PLACE AND GROWTH INTERNAL MEMORANDUM

Your Ref: 21/04275/OUT

APPLICATION FOR PLANNING PERMISSION PLANNING POLICY CONSULTATION RESPONSE

Planning Application No.	21/04275/OUT
Address / Location	Part OS Parcel 8149 Adj Lords Lane and SE Of Hawkwell Farm, Lords Lane, Bicester
Proposal	<p>OUTLINE - with all matters reserved except for Access - Mixed Use Development of up to 3,100 dwellings (including extra care); residential and care accommodation(C2); mixed use local centre (comprising commercial, business and service uses, residential uses, C2 uses, local community uses (F2(a) and F2(b)), hot food takeaways, public house, wine bar); employment area (B2, B8, E(g)); learning and non-residential institutions (Class F1) including primary school (plus land to allow extension of existing Gagle Brook primary school); green Infrastructure including formal (including playing fields) and informal open space, allotments, landscape, biodiversity and amenity space; burial ground; play space (including Neaps/Leaps/MUGA); changing facilities; ground mounted photovoltaic arrays; sustainable drainage systems; movement network comprising new highway, cycle and pedestrian routes and access from highwa

Development Framework Plan

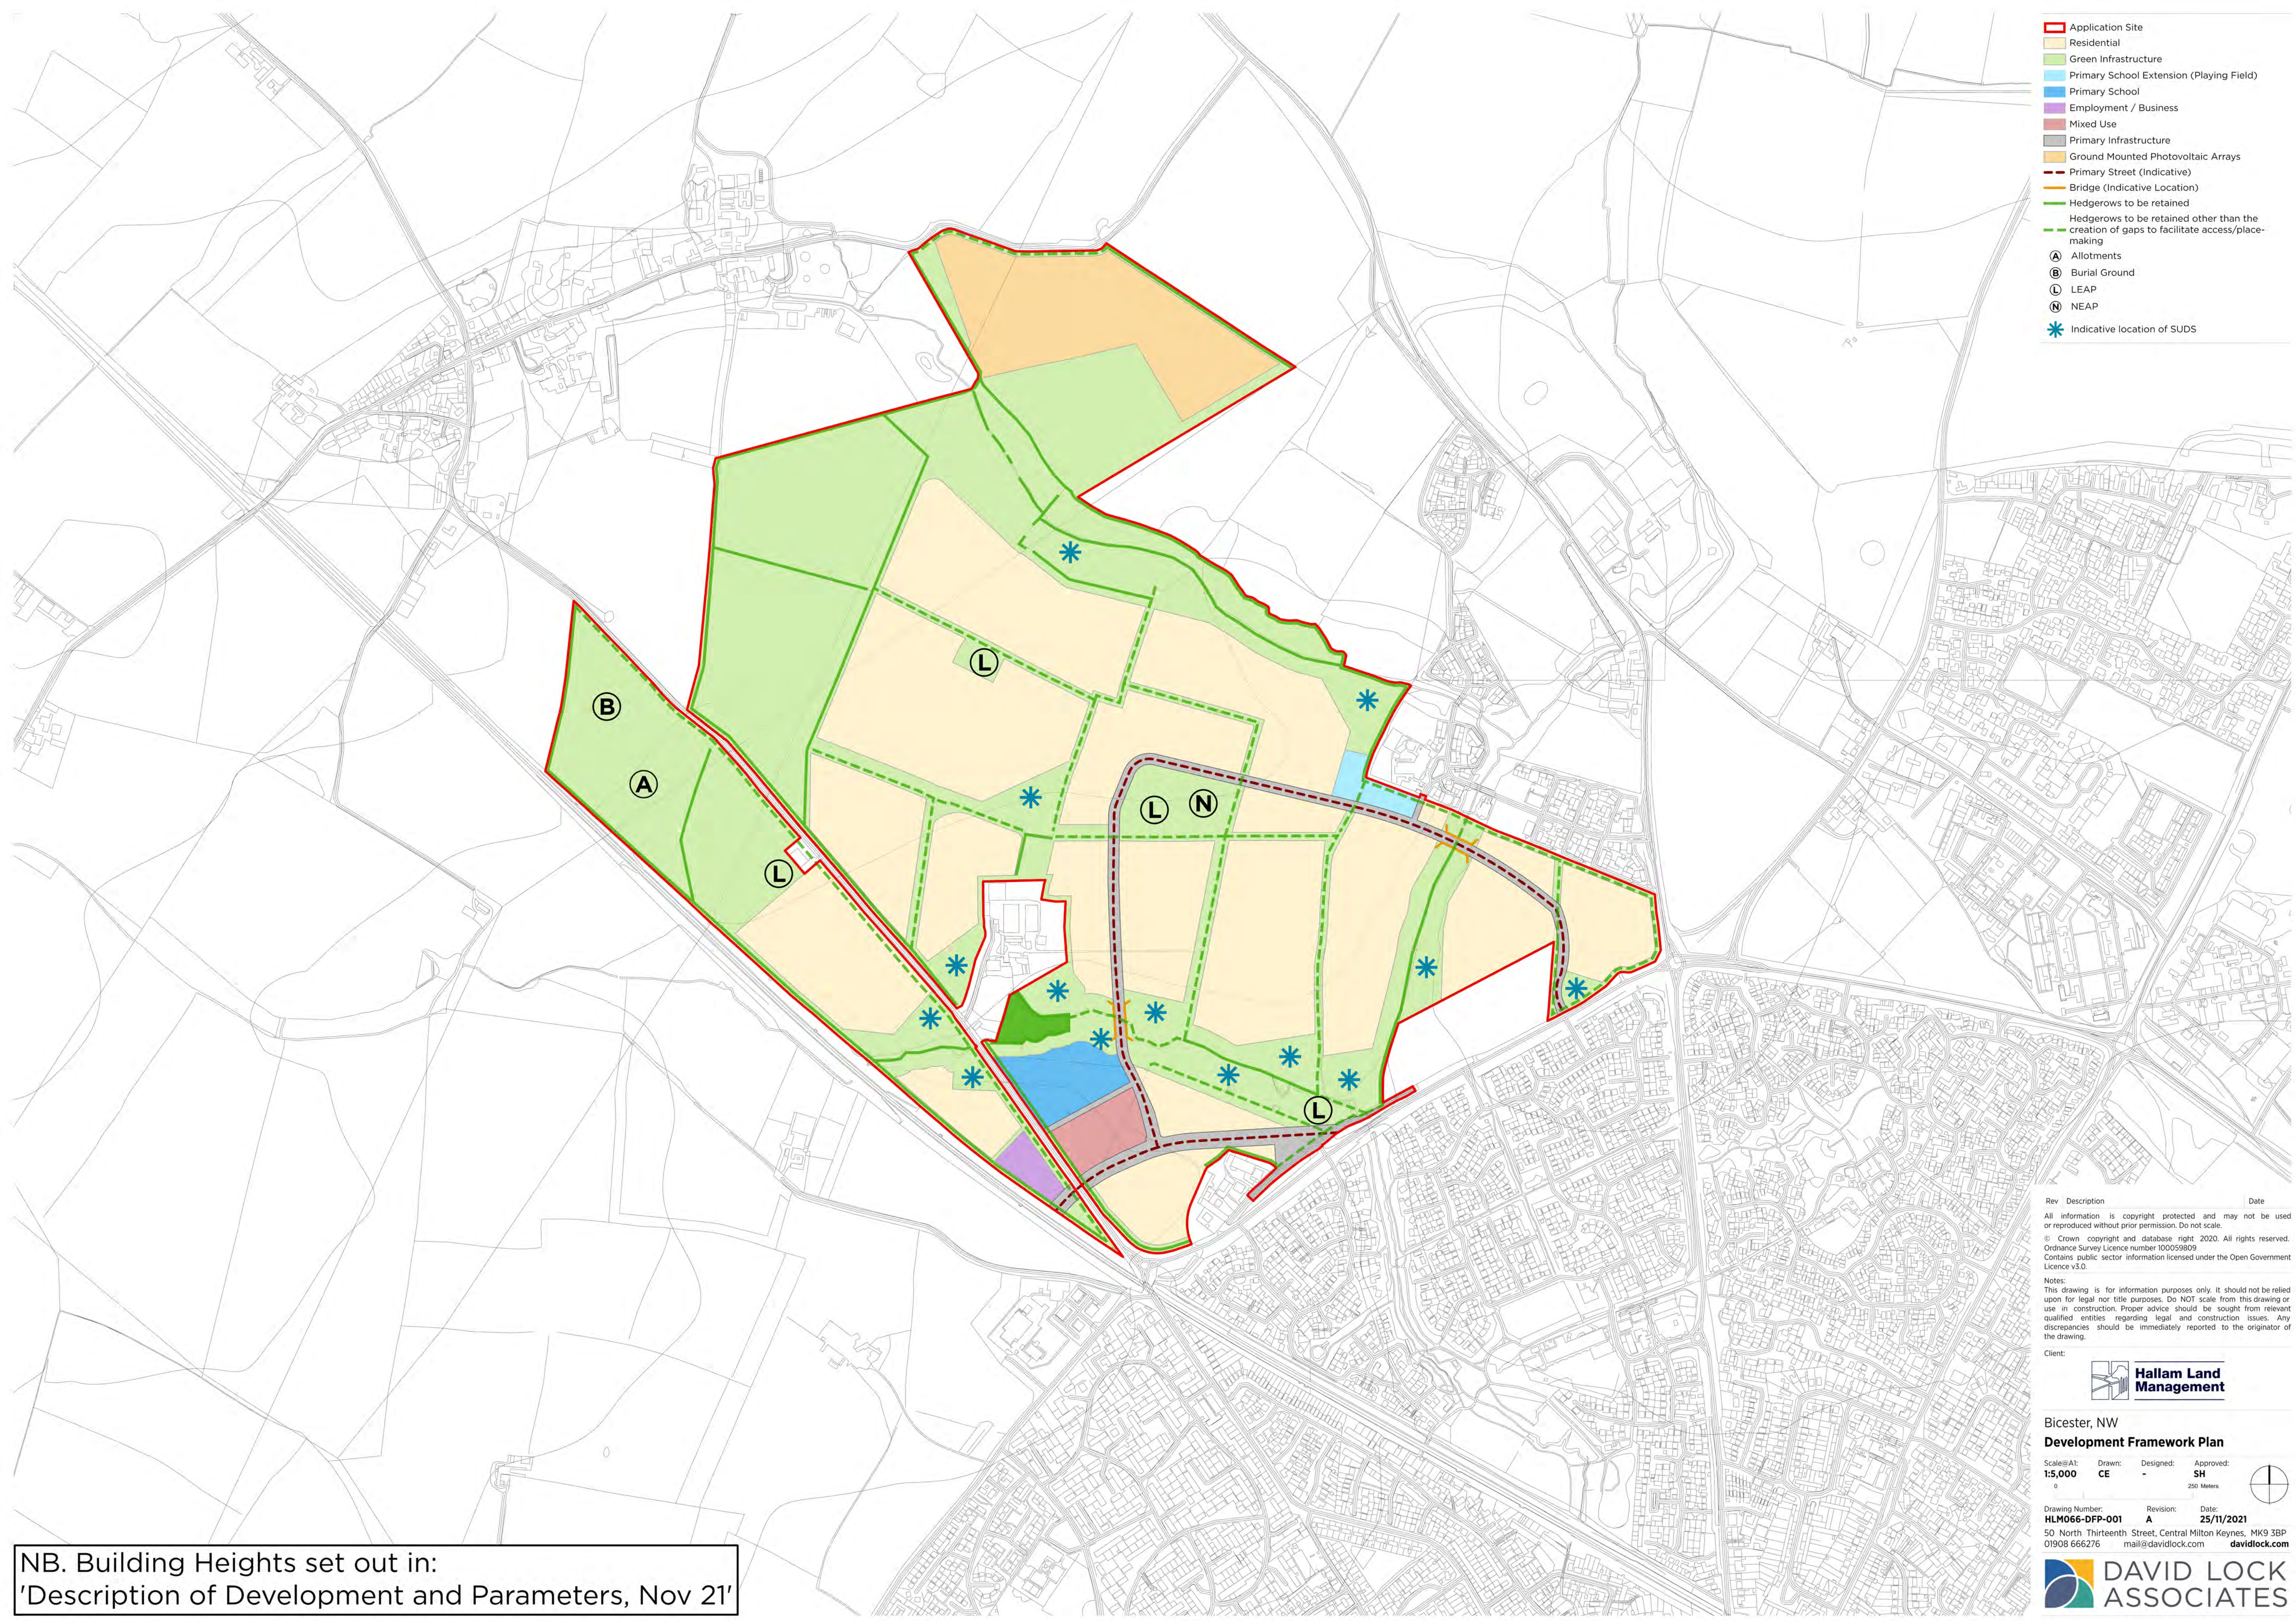
- The application, although in outline with all matters reserved except access, is supported by a development framework plan. Elements of this framework plan do not accord with the SPD Masterplan. In particular:

- The burial ground and allotments have been located to an area beyond the LP allocation.
 - Significant residential development is proposed in areas identified for GI in the masterplan;

- The location of the proposed primary school in the SW of the site does not accord with the Masterplan and does not have a frontage to Lords Lane
 - No sports pitches appear to be provided within the site.

- The application states that 40% of the site will comprise green space, however, the majority of this space is proposed outside the allocated Policy Bicester 1 site. The provision of open space within the allocated site is significantly below that required by Policy Bicester 1 and is therefore contrary to the policy.
